CITY OF ALBUQUERQUE

March 10, 2020

RE: 142 40th Street SW
Grading & Drainage Plan
Engineer's Stamp Date: 02/21/20
Hydrology File: K12D037

Based upon the information provided in your submittal received 02/28/2020, the Grading & Drainage Plan **is not** approved for Building Permit and Grading Permit. The following comments need to be addressed for approval of the above referenced project:

**142 40TH STREET, SW  
GRADING AND DRAINAGE PLAN**

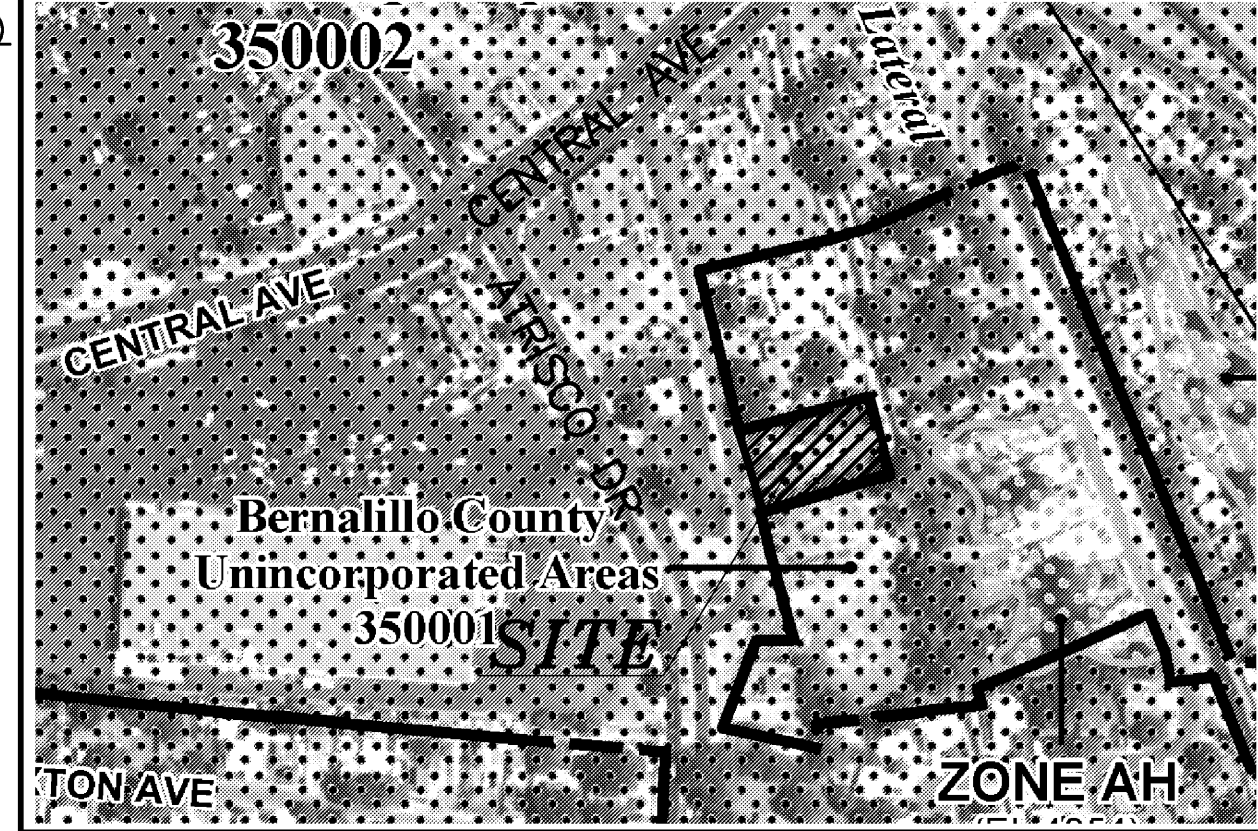
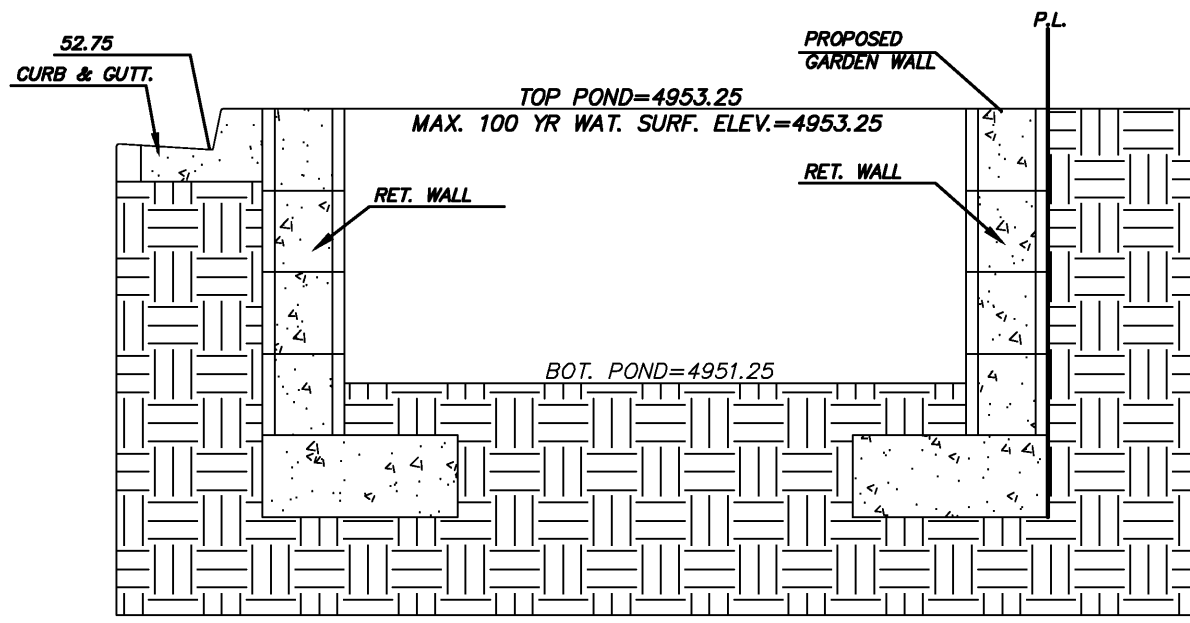
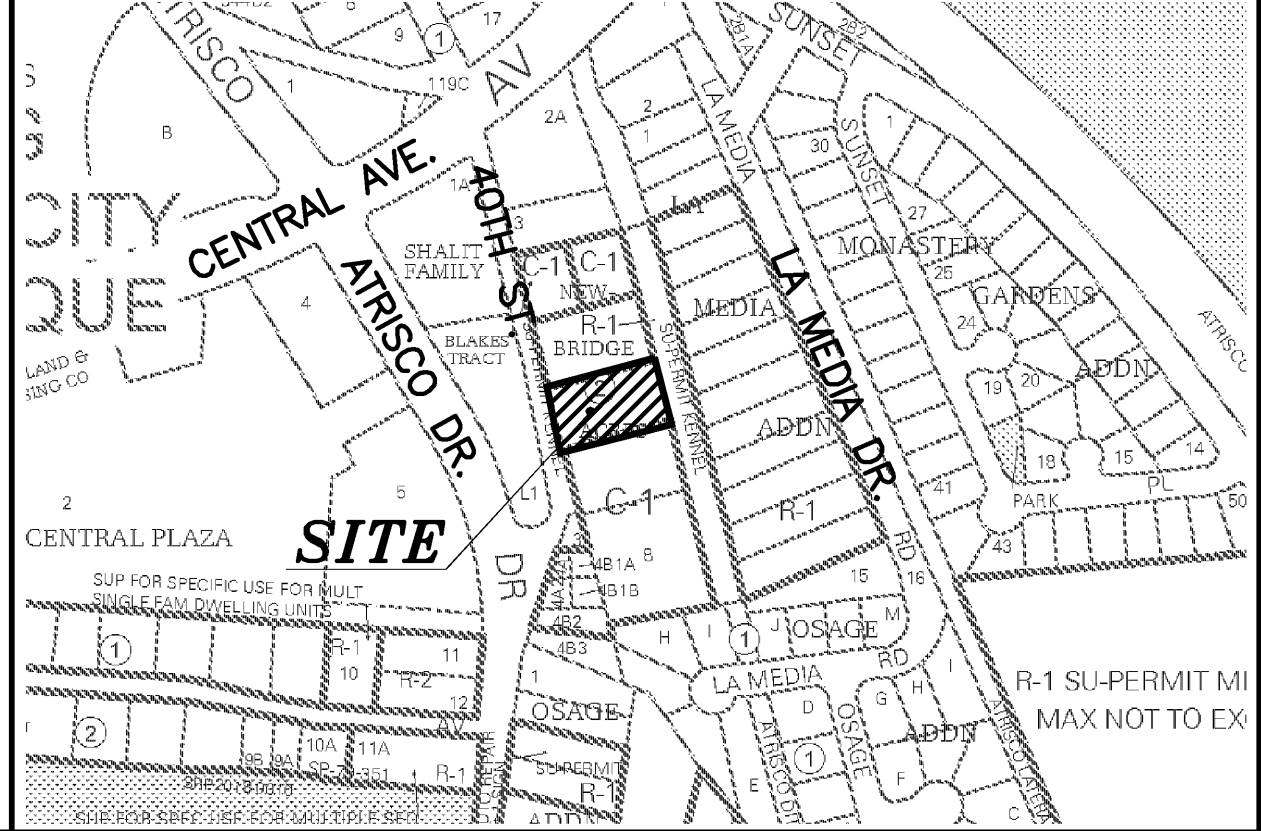
2. Please provide existing topographic survey information with existing grades on the site. Without this information, it is difficult to tell what is going on with the site. Also provide the Benchmark information (location, description and elevation) for the survey contour information provided.

3. There is a proposed retention pond right up against the existing structure that is over the property line. How is this structure being protected? Is the property Owner taking the liability of damaging this structure?

4. There are several errors in the G&D with missing line work, extra line work, line work not matching the Legend, or line work not labeled. There are several texts with line work under them which makes it hard to read. There are two hatched areas not labeled. Please clean up the G&D.

5. Since this site is in the Valley region, please follow Chapter 22 Section 5.G (Flat Grading Scheme). The following conditions must be applied to the site:

- The maximum percent impervious of the lot and the contributing area may not be greater than 45%.
 - Pad elevation shall be a minimum of one (1) foot above the 100 year 10-day stormwater surface elevation.

- The flow between the front yard and back yard cannot be obstructed. The stormwater must be allowed to equalize to the same level between the front yard and back yard.

- A permanent perimeter wall or barrier around the development is required to contain the 100 year 24 hour storm developed runoff.
 - The high point of the street should be four inches above the 100 year 10-day stormwater surface elevation.

6. In your narrative and drainage calculations, it talks about historical flows. This is not allowed by the DPM. Please follow the Flat Grading Scheme outlined in the DPM and in comment #4.

7. Since this is in the Valley region and will not be allowed to discharge into 40th Street, please remove the proposed sidewalk culvert, calculations, and the SO-19 notes.

8. Provide sections through each retention pond. This should show proposed retaining walls, the retention volume water surface elevation, property/ROW lines, existing and proposed grades. In accordance with DPM Ch.22, section 5 part B, grading and wall construction near the property line may not endanger adjacent property or constrain its use.

9. If the proposed retaining wall will create such an encroachment, written agreement from both landowners must be provided for such work. Written permission must include: signature of the property owner or owners representative, statement that undersigned is the owner or authorized representative, permission to construct the encroachment with a brief description of the encroachment.
